Appeal Decision

Appeal Ref: APP/T2350/D/16/3157387

Blue Trees, Manor Road, Copster Green, Lancashire, BB1 9EP

- The appeal is made under section 78 of the Town and Country Planning Act 1990 against a refusal to grant planning permission.
 - The appeal is made by Mr J Rowley against the decision of Ribble Valley Borough Council.
 - The application Ref 3/2016/0333, dated 11 April 2016, was refused by notice dated 6 June 2016.
 - The development proposed is resubmission of application ref 3/2016/0114, for the erection of garage and boundary fence.
-

Drawing  
Proposed Garage and fence details  
Date January 2016 Drawn by Craig Buck Scales 1:50+200 @ A1

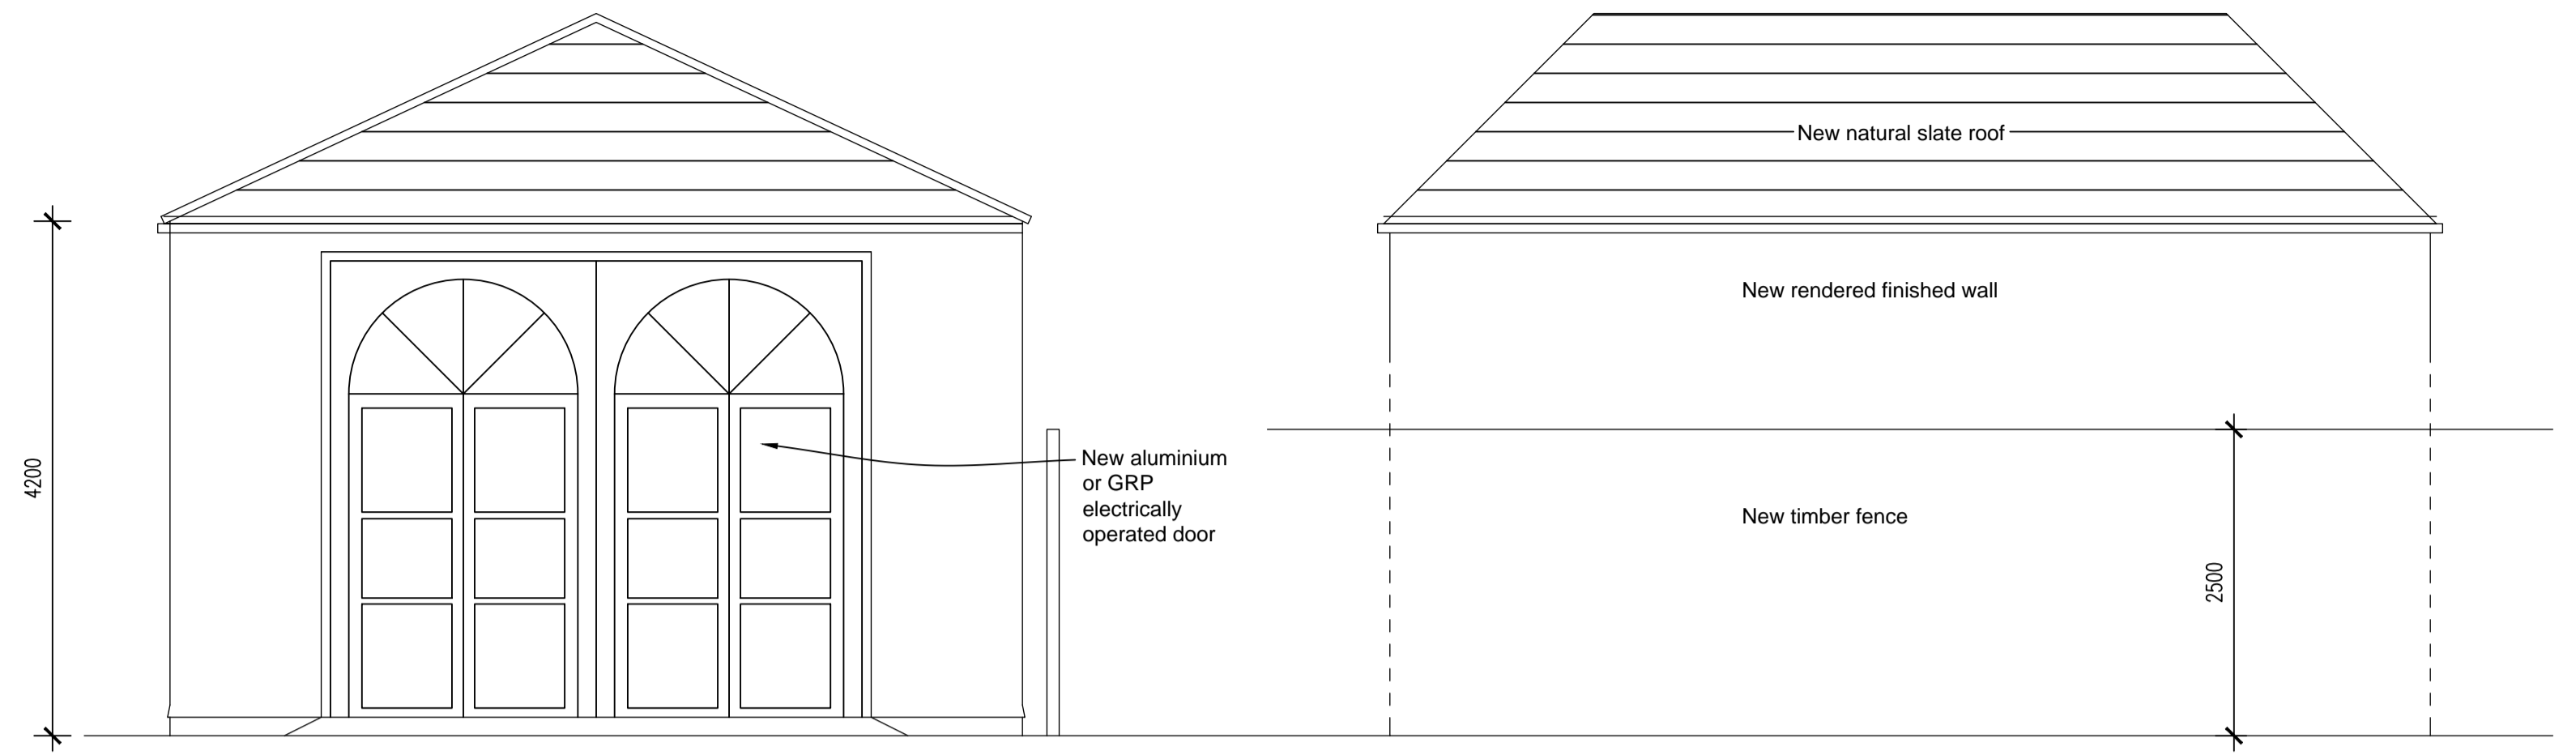
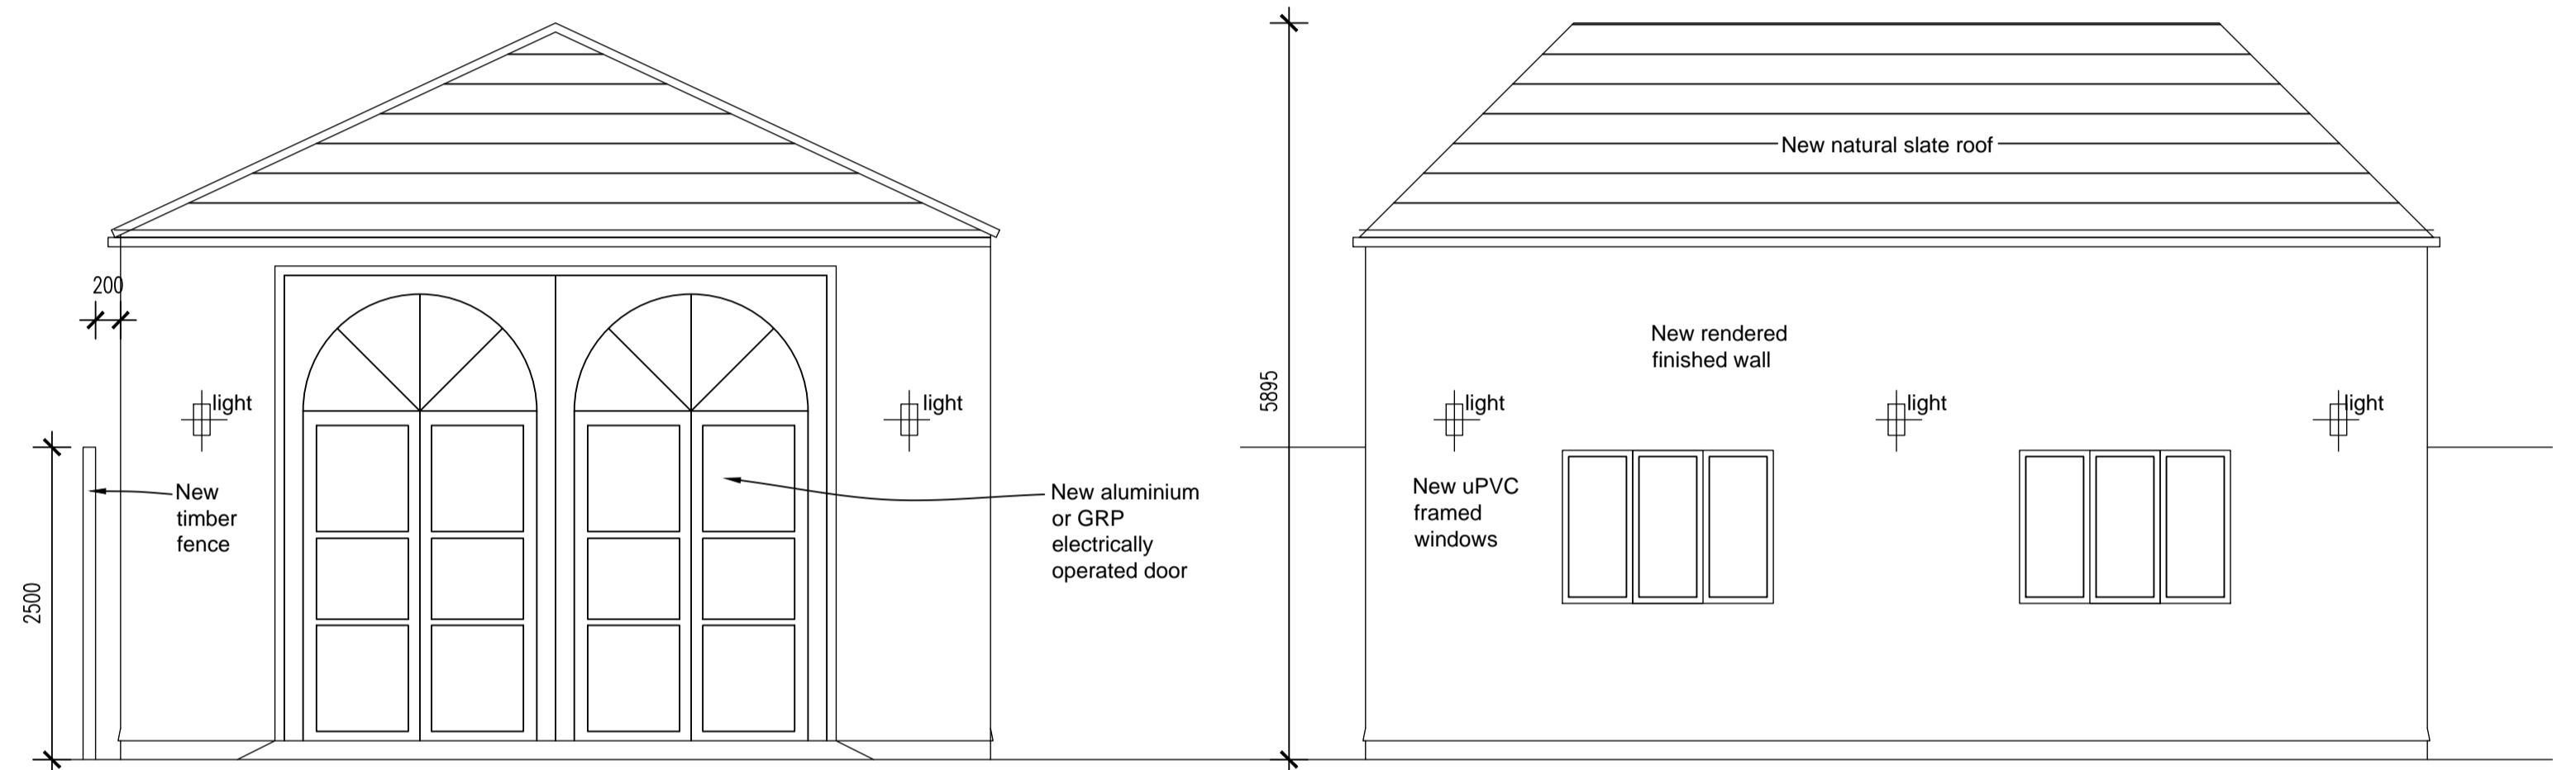
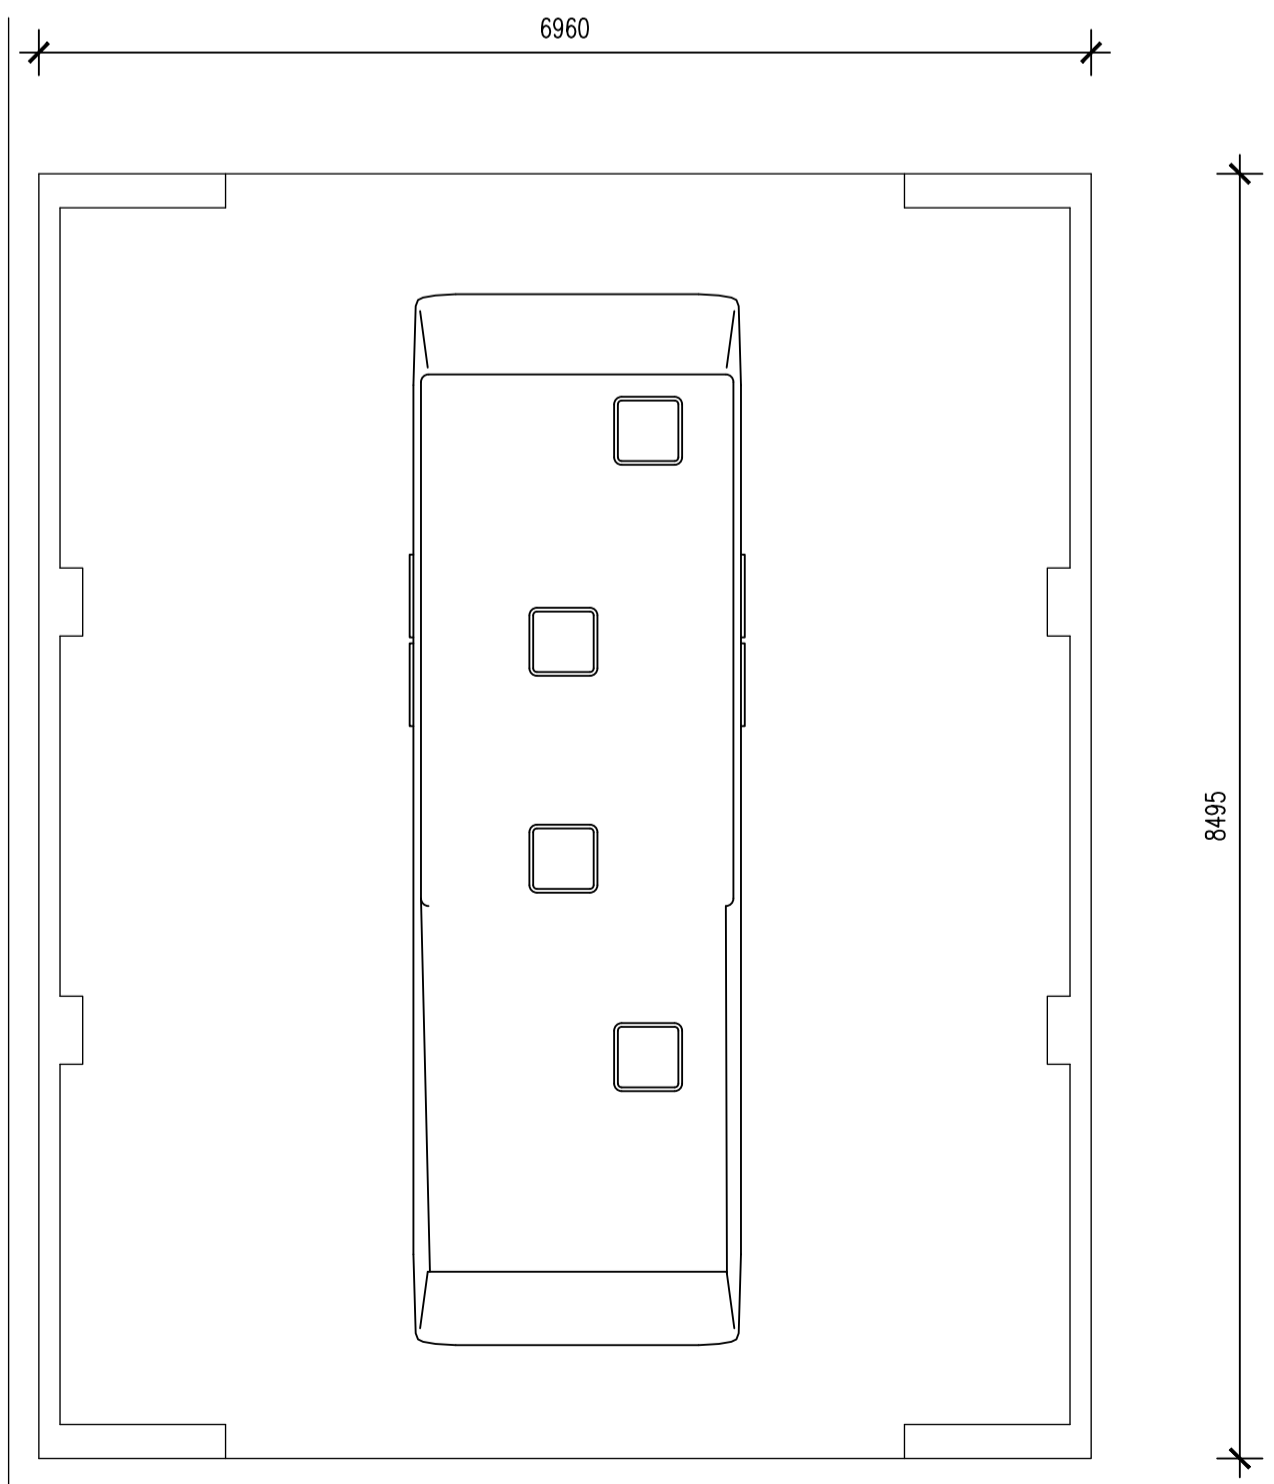
4. The proposed garage would be large and the appellant states that it is required to accommodate a caravan / motorhome. It would be 4.2 metres in height to the eaves and almost 5.9 metres to the ridge. The garage would be visible from road through the gap between Hill Top Bungalow and Oaksmead.
 5. The previous Inspector found that the overall scale of the garage would not reflect the semi-rural residential character of Copster Green, and would appear incongruous to the area. These observations equally apply to the current
-

appeal proposal, which is very similar in scale and design. The garage would be a large and intrusive presence that would be at odds with the character of the area. The fact that it would only be visible from a section of the road does not alter my view in this regard.

6. The proposed fence would extend along the boundary with Oaksmead, and would be 2.5 metres in height along most of its length. Whilst there would be a step down in height closer to the road, it would still be prominent in views along the street. The fence would also be taller and of a different construction to other boundary treatments in the vicinity. In my view, it would be visually intrusive and out of keeping with the character of the area.

9. The proposed garage would be located next to the boundary with Oaksmead. The previous Inspector found that the earlier proposal was visually intrusive when viewed from the garden of Oaksmead. The current appeal scheme is the same height as that proposal, and is in the same location next to the garden to Oaksmead. In my view, it would be visually oppressive and overbearing to users of the rear garden.

10. The long stretch of fencing along the boundary would be lower in height than the existing hedge, and would not therefore have an unacceptable overbearing impact on the rear windows or garden of Oaksmead. However, at the front of the property, where the boundary is currently low and supplemented with planting, the proposed 2.5 m high fence would harmfully reduce the outlook from the nearby ground floor window to Oaksmead. Whilst this impact may change if the approved extension to Oaksmead is built, construction work did not appear to have started at the time of my site visit. I cannot therefore be certain that this extension will be built.
